**DEPARTMENT OF THE AIR FORCE  
UNITED STATES SPACE FORCE  
SPACE BASE DELTA 1**

Thank you for notifying Schriever Space Force Base (SFB) of the Flying Horse East (FHE) Phase 1 Sketch Plan project (File Number SKP242). We appreciate the opportunity to review this proposed development application and offer the following comments related to specific project documents.

SKETCH PLAN

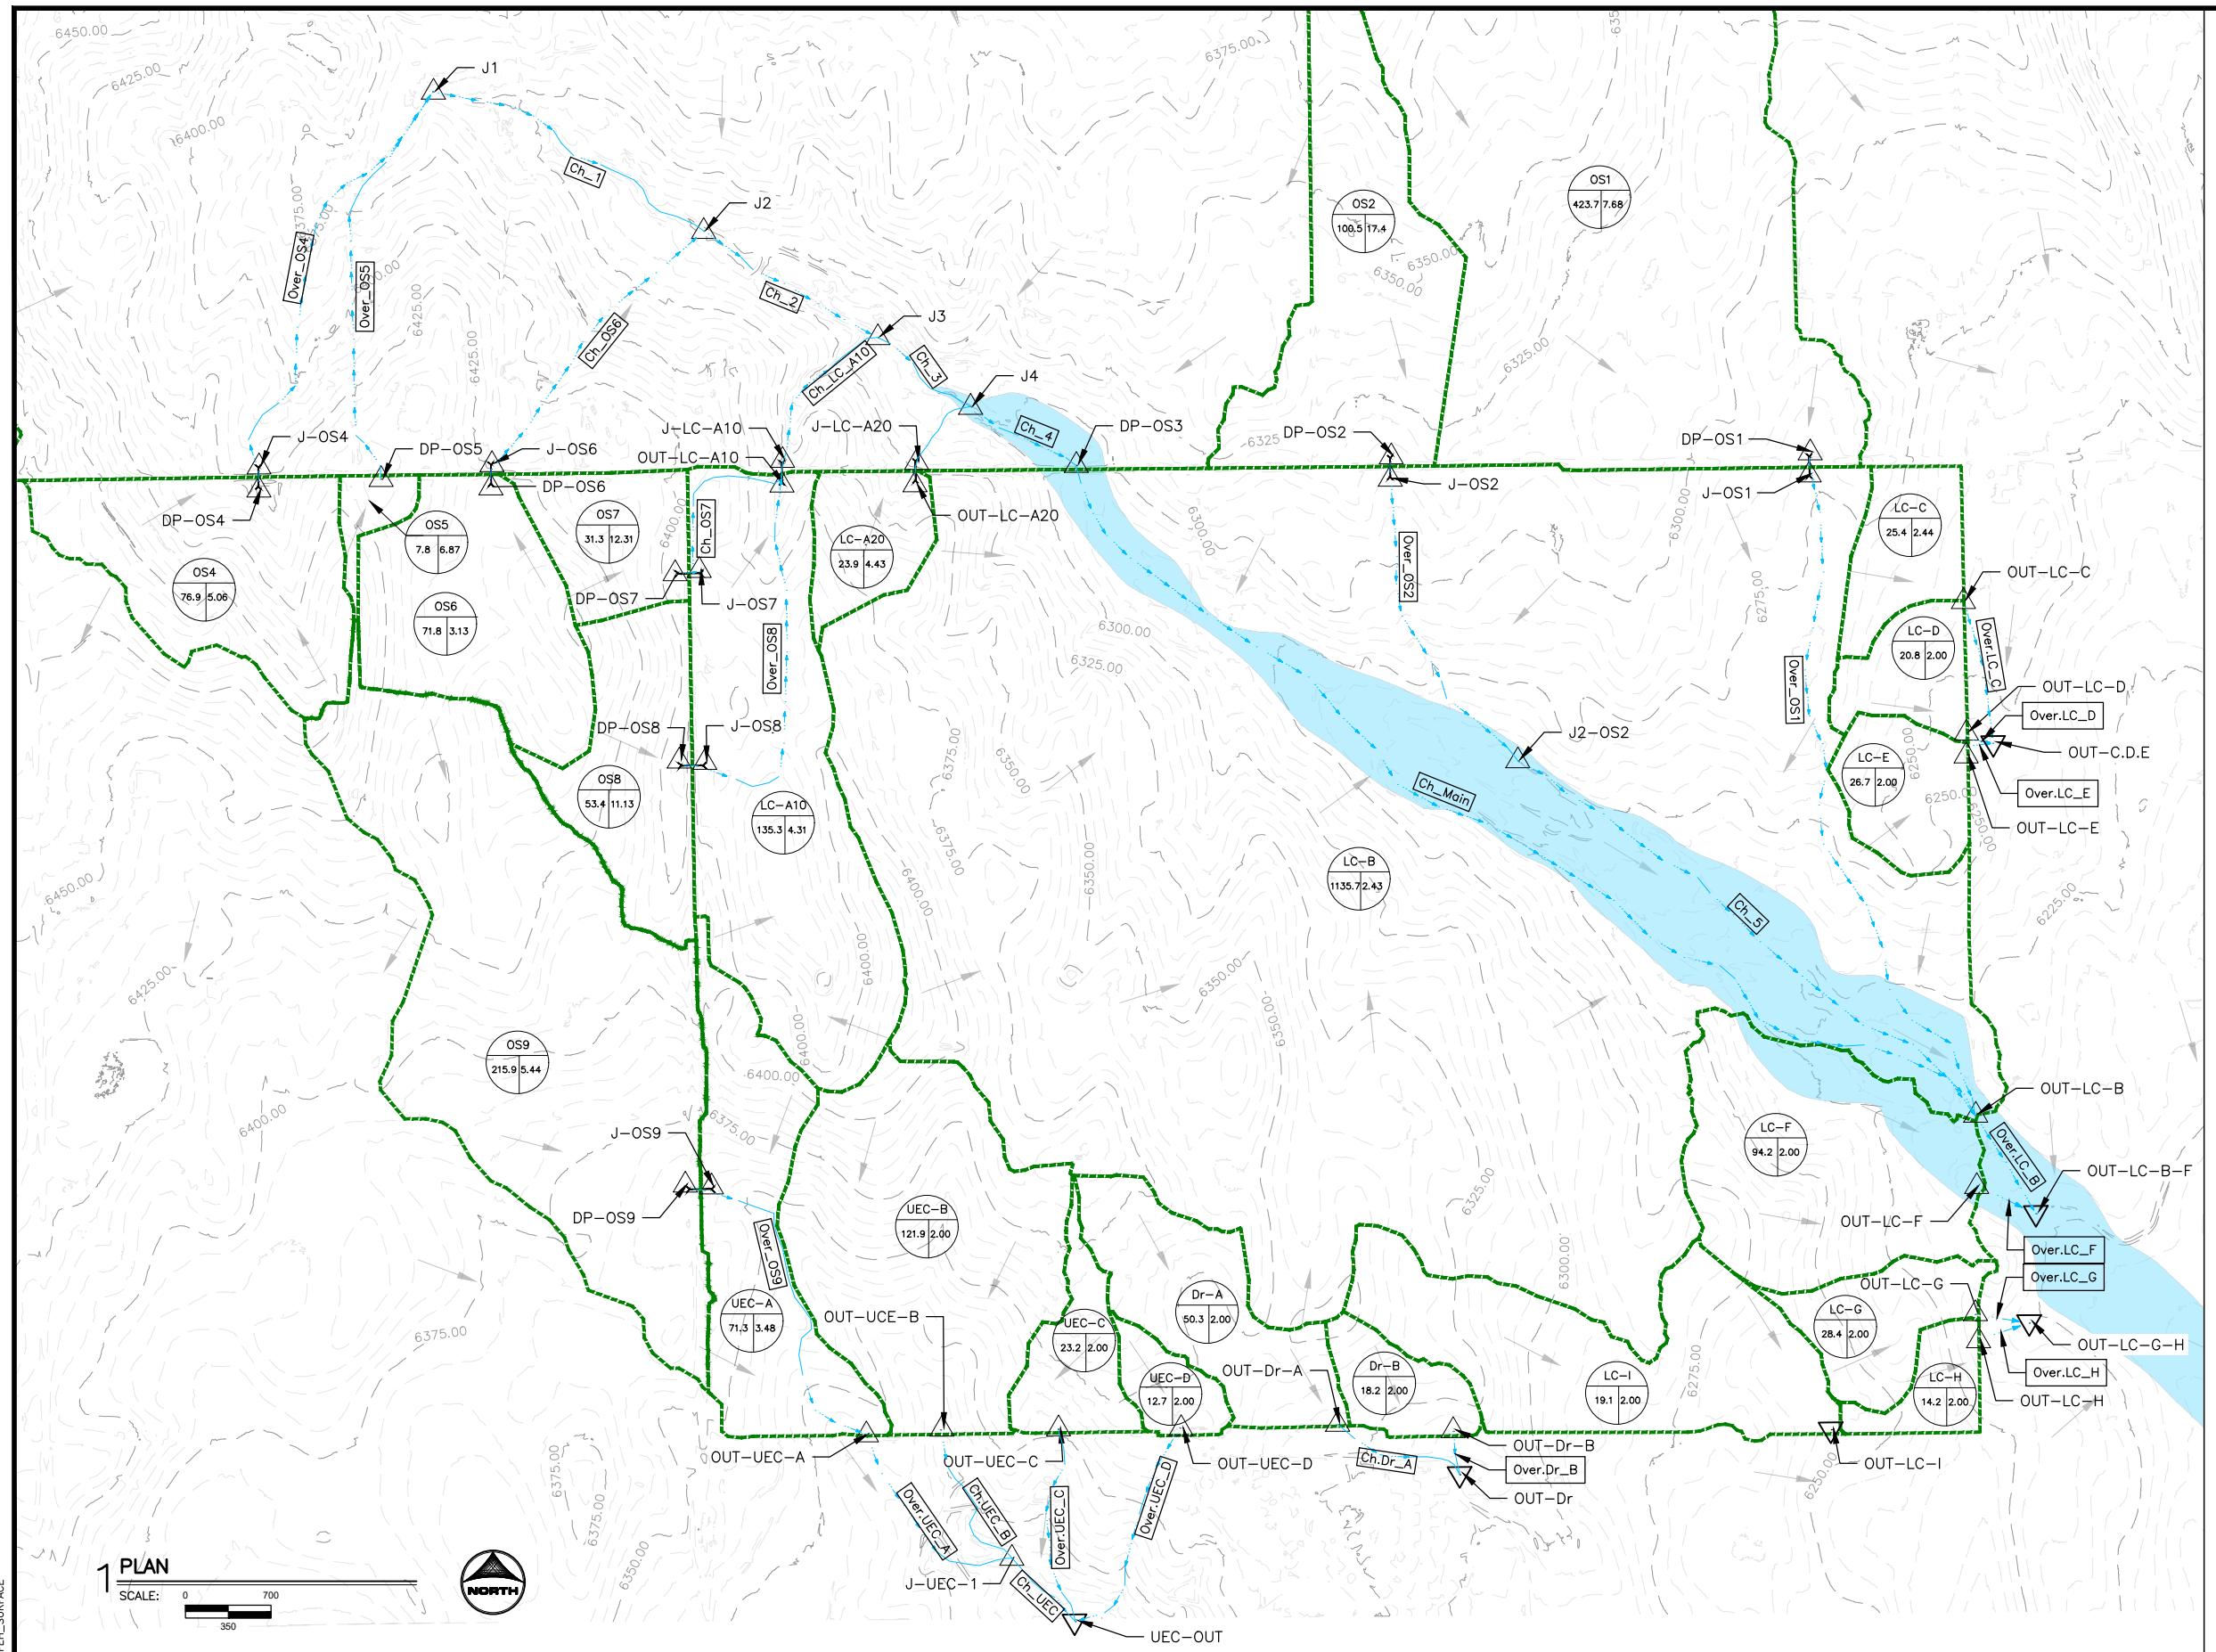
Sketch Plan: A small open space strip of land is identified just north of the installation. Schriever SFB asks the County to request the applicant provide the estimated distance from the installation perimeter and building heights and other pertinent details to ensure compatibility. Schriever SFB asks the County to request the applicant consider providing an open space buffer as a replacement for the proposed Business Park land use as an appropriate compatible use transition. Also, the Sketch Plan identifies two sewer lift stations just north of the installation. Schriever SFB asks the County to request the applicant to consider placing the infrastructure further to the north to eliminate the potential for any flooding or odors onto Schriever SFB if the lift stations malfunction.
